Our Reference: SYD17/00866/02

Your Ref: SSD 8544

Department of Planning & Environment
GPO Box 39
SYDNEY NSW 2001

**GLEBE ISLAND AGGREGATE HANDLING AND CONCRETE BATCHING FACILITY
GLEBE ISLAND, JAMES CRAIG ROAD, ROZELLE – NOTICE OF EXHIBITION**

Appendix C. Swept path analysis at The Crescent / James Craig Road

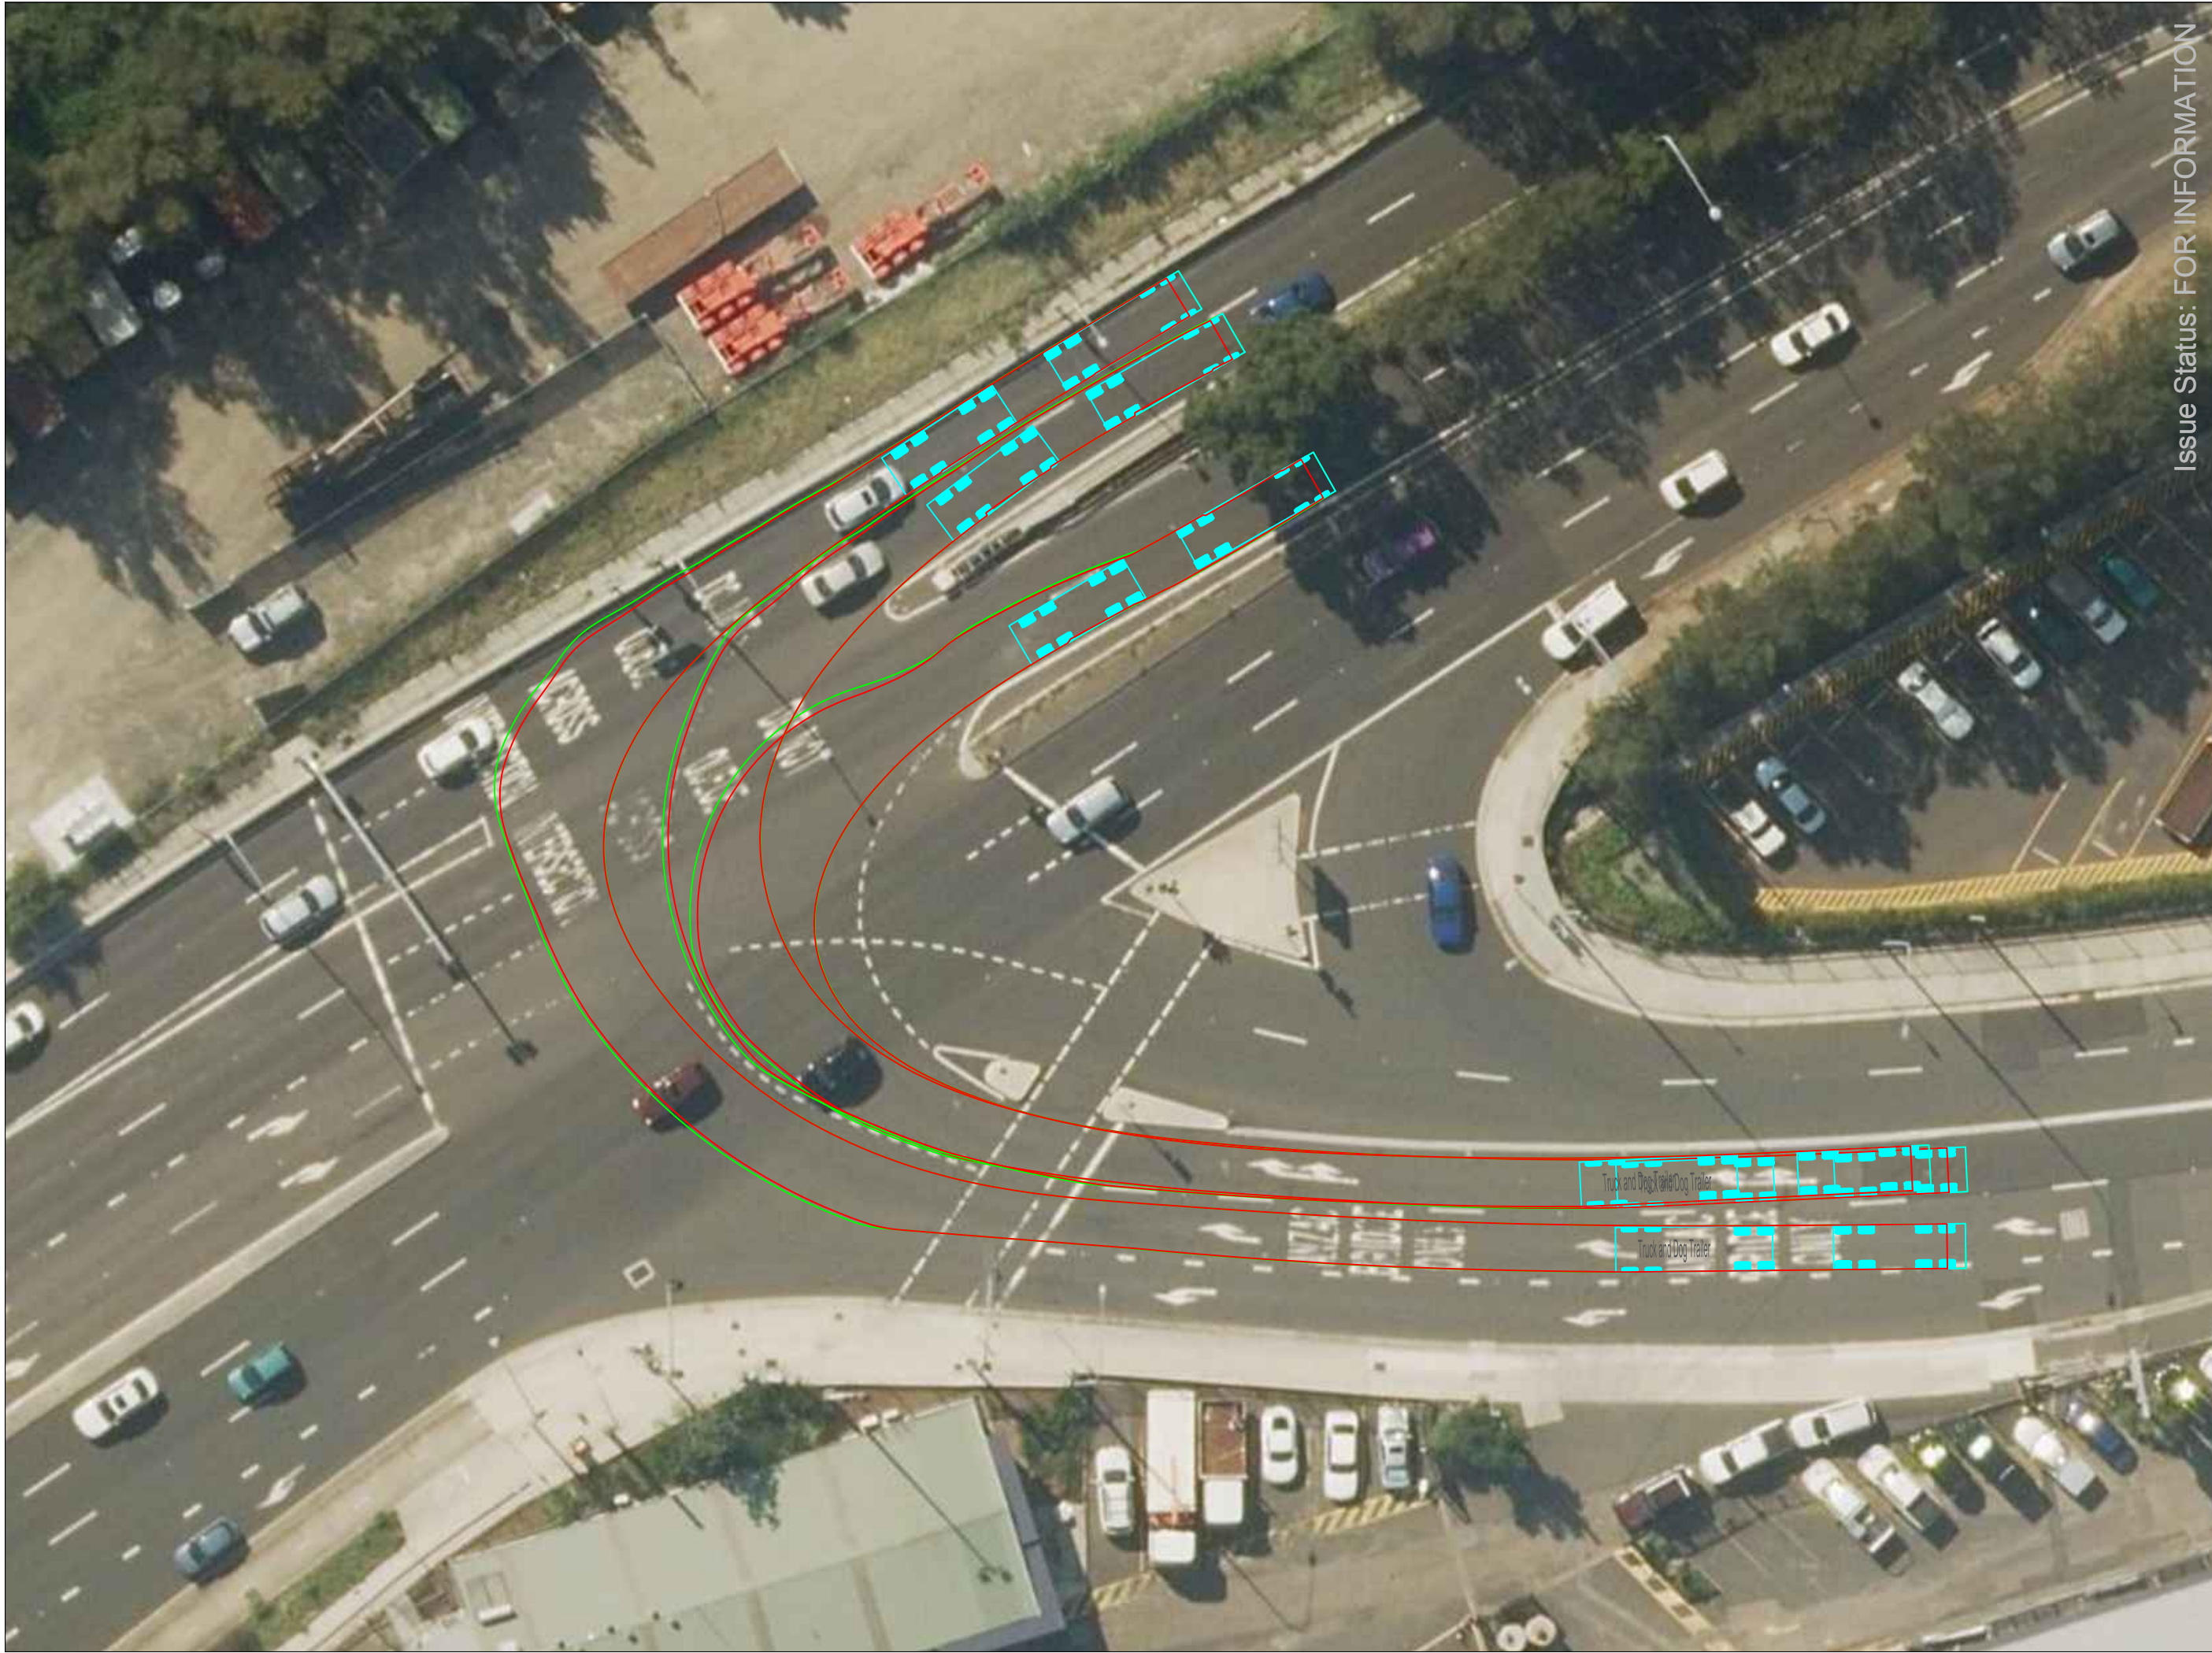
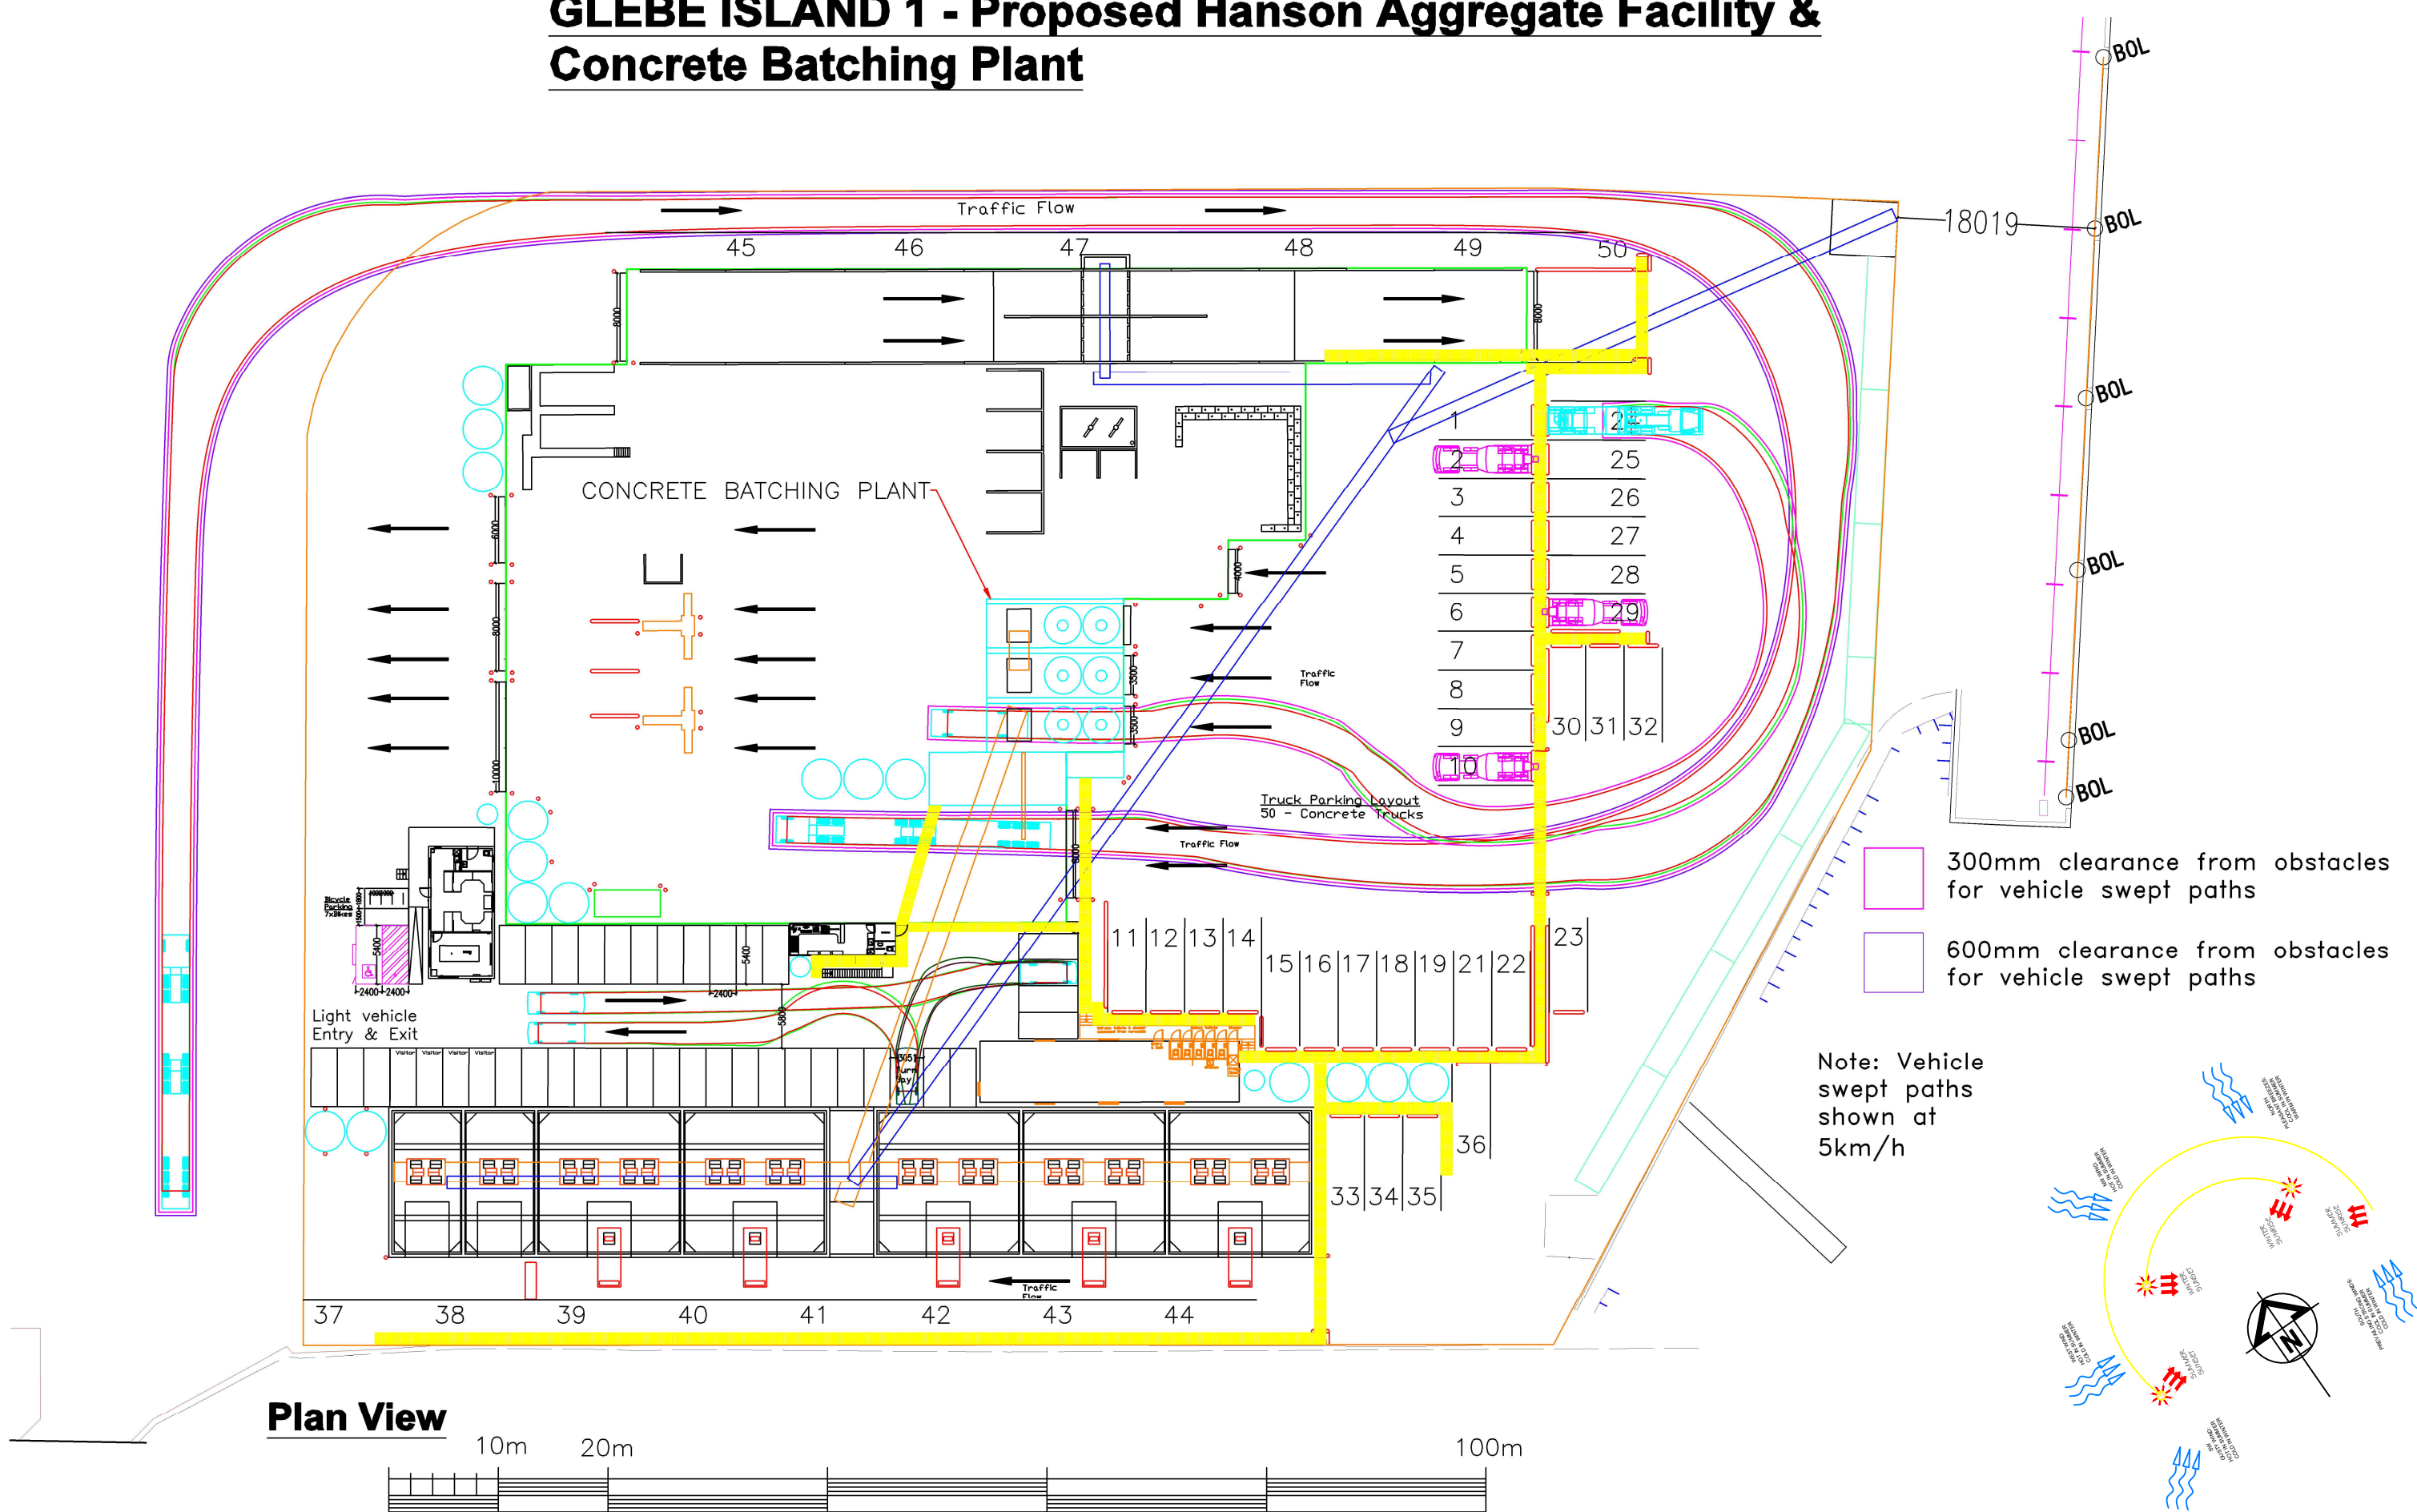
1. A swept path assessment of Cement, Aggregate and Concrete trucks that are proposed to turn right at the intersection of The Crescent / James Craig Road. Roads and Maritime is concerned that additional large trucks will reduce the ability for two vehicles to turn side-by-side, leading to a reduction in capacity of the right turn movement beyond that envisaged. Additional information is requested to be provided on whether the traffic capacity of the right turn is likely to reduce based on the swept path assessment and if so, this is to be reflected in the traffic modelling.
